**RESPONSE TO CONSULTATION ON RIBBLE VALLEY CORE STRATEGY EVIDENCE DOCUMENTS
STRATEGIC HOUSING LAND AVAILABILITY ASSESSMENT
ASSESSMENT OF SITE 142 FOR RESIDENTIAL DEVELOPMENT
LAND ADJACENT KILN CLOSE, CHATBURN ROAD, CLITHEROE**

Please find below our response to the above consultation, specifically relating to site 142 and made on behalf of a prospective developer.

Site 142 Adjacent Kirk Close, Chatburn Road, Clitheroe

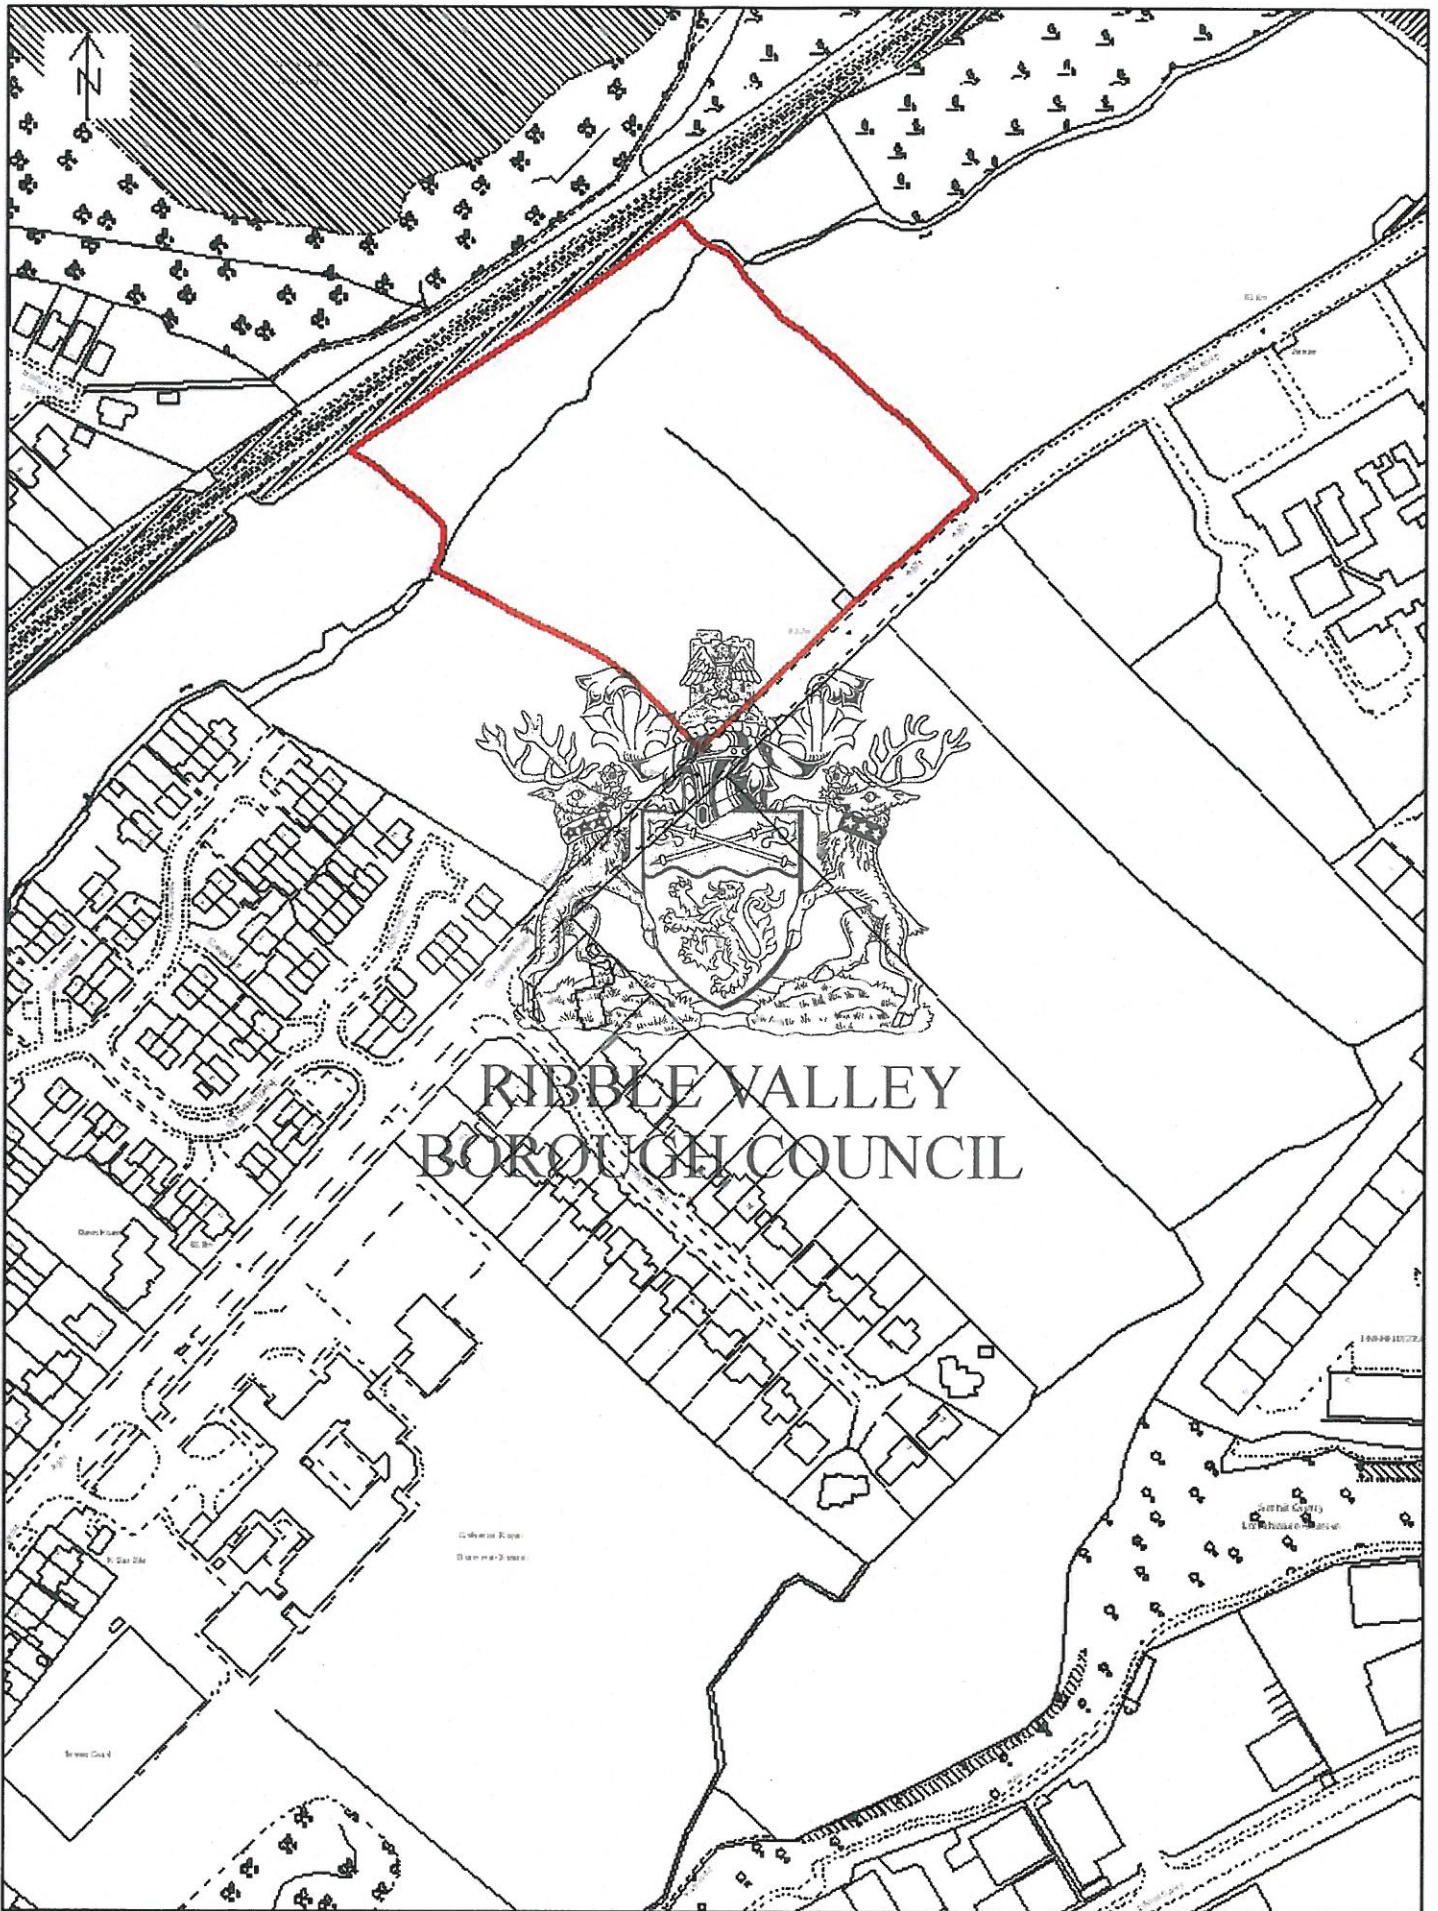
The indication that there are employment uses beyond the railway line should be omitted. This is factually incorrect.

The visual prominence of the site is noted as 'very prominent'. This is not borne out by an inspection of the site. The site lies at a lower level than the adjoining Chatburn Road and is in great part shielded to view by a frontage wall. In any event, the site is viewed in the context of existing development at Kiln Close and Cringle Way (to the south of the railway) and Moorland Crescent to the north of the railway. The site should be described as not visually prominent.

We note that the site is assessed as 'not suitable', failing one of the tests of suitability.

The reason for the site failing one of the tests of suitability is not set out in the site assessment sheet. However, you advised that the reason in this instance is 5) – Is the site in Flood Zone 2 or 3?

An extract from the EA flood risk map is appended. It shows that only a very small portion of the site immediately adjacent to the stream falls within the Flood Zones 2 /3. The bulk of that area is the land to the north of the stream. That is, land that might logically be retained as an open area, as per the land to the north of the stream adjacent to the Kiln Close development.

Accordingly, we submit that the flood risk issue is not one that would preclude a housing development at the site and / or provide reason for regarding the site as 'not suitable'. Rather, it would be more appropriate to adjust the net developable area accordingly. Indeed, this is the approach advocated in your August 2013 SHLAA report, paragraphs 8.34 to 8.36. In this instance, excluding the areas identified as at risk of flood and the land to the north of the stream the net developable area would be 1.5ha.

We can confirm that the site is in a single ownership (not two as stated), aiding the process of delivering development at the site.

We note that the site is listed as being included within the 6 – 10 year supply period. For the reasons set out above in relation to suitability and the site's availability and achievability, we submit that the site should be included within the 0-5 year supply period.

- S1: Main Development Location – the site has presumably been scored 3 on the basis that the site is regarded as adjacent to Clitheroe, based on the Local Plan Proposals Map settlement boundary. We do not consider this to be a sound basis for scoring the site given the Local Plan was adopted some 15 years ago and is regarded as out of date. This is most particularly in relation to the supply of land for housing. In addition, the Council acknowledges that greenfield sites on the

periphery of settlements will have to be developed to satisfy housing needs. Thus, the site should score 5;

- S7: Suitable Infrastructure – highways and utilities are available at the site boundary and, thus, the site should score 5;
- S11: Risk of River Flooding – we have addressed this issue above. Whilst the net developable area may be adjusted to take account of the issue, the greater part of the site is wholly unaffected by any flood risk. Thus, the site should score 5;

- S16: Site Contains a TPO – it is acknowledged that some field boundary trees are covered by a TPO. However, that is not an undue constraint on the developability or sustainability of the site. Thus, the site should score 5; and

- S19: Any Bad Neighbour Land Uses – it is assumed that the site has been scored 3 on the basis of a note under other comments that there is a school opposite. That is incorrect, the nearest school is The Grammar School to the south west further along Chatburn Road,. Indeed, the very closest points of the SHLAA site and the school grounds are some 170 metres apart. Thus, the site should score 5.

We would request that you make appropriate amendments to the site assessment to indicate that it is 'suitable'.
